OFFICIAL NOTIFICATION OF DECISION

Project# PR-2018-001579
Application#
SD-2021-00035 PRELIMINARY/FINAL PLAT

**PARCEL Z FINAL PLAT PARCEL Z AND TRACTS
A, D, E, F, F-1, G & H, WINROCK CENTER
ADDITION** zoned MX-H, located at **2100
LOUISIANA BLVD NE between INDIAN
SCHOOL and I-40** containing approximately
28.86 acre(s). (J-19)

SHEET 14 OF 14

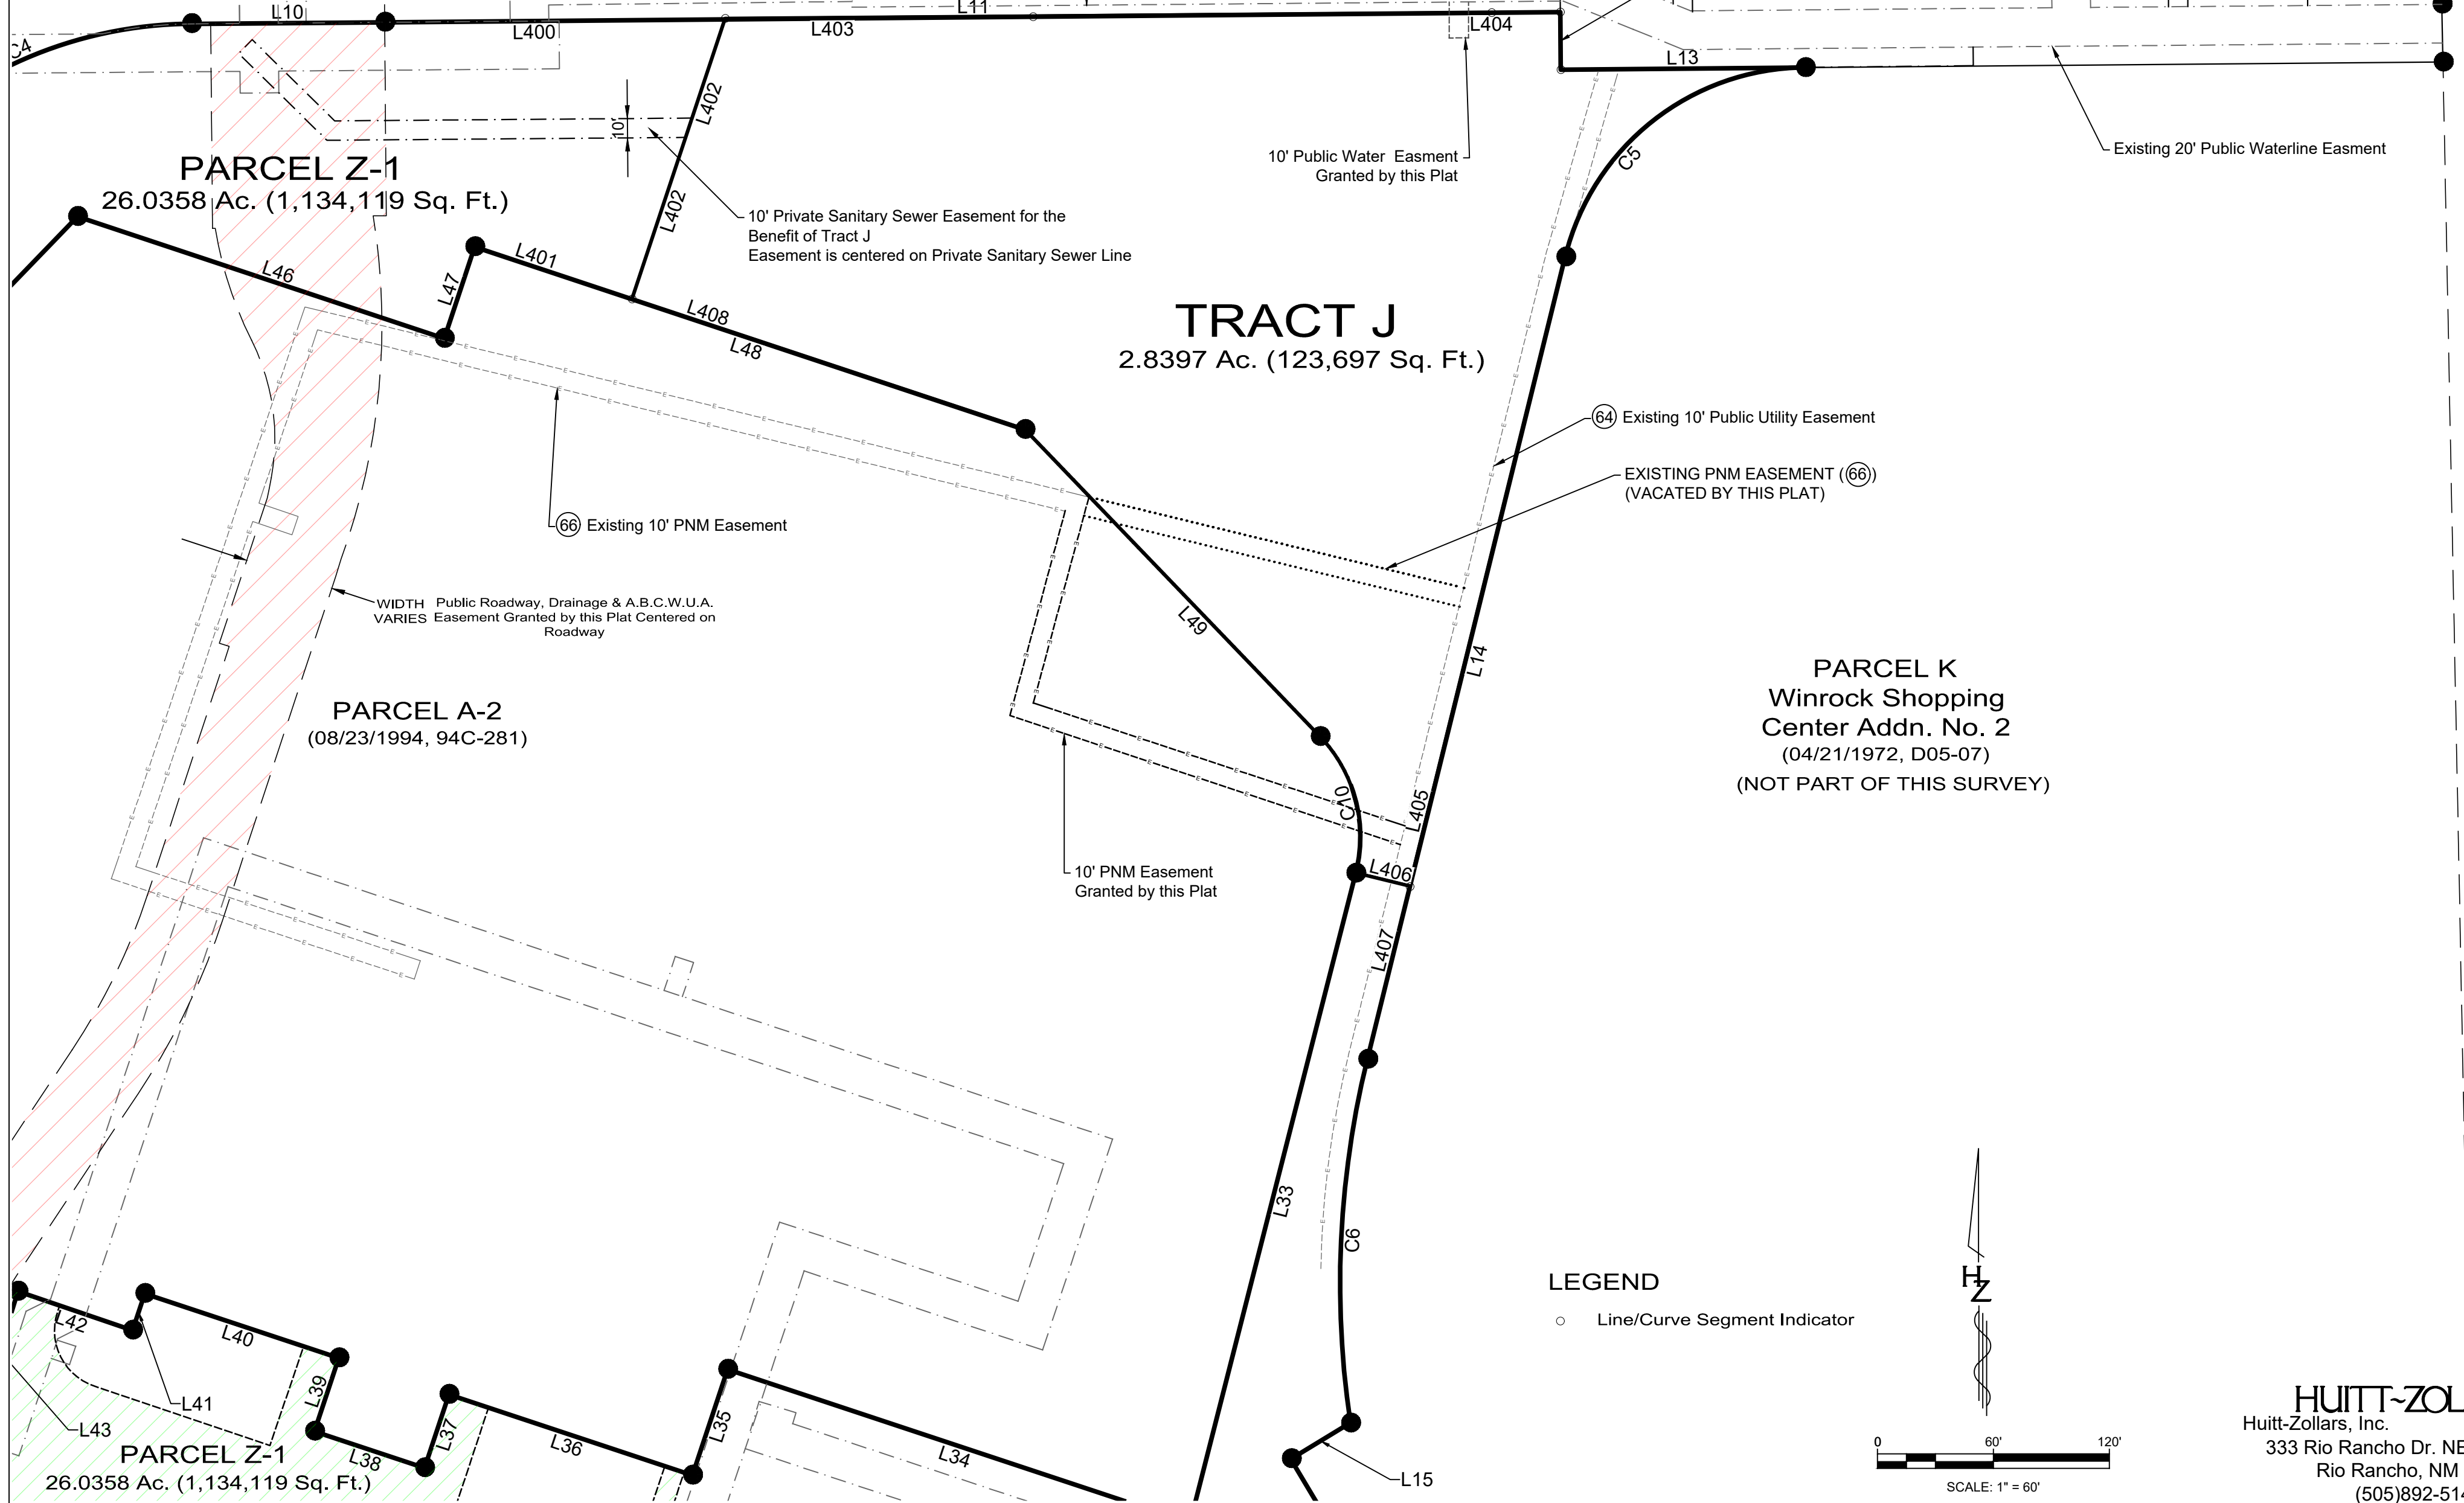
1. Final sign-off is delegated to ABCWUA for the correction of a call-out for an easement on Sheet 14, the addition of a dimension of a granted ABCWUA easement within Tract J on Sheet 14, and a paper easement recorded for ABCWUA water and sewer in a location north of Tract J within parcel D-1A.
2. Final sign-off is delegated to Planning for utility/AMAFCA signatures, AGIS DXF file, and recorded IIA.
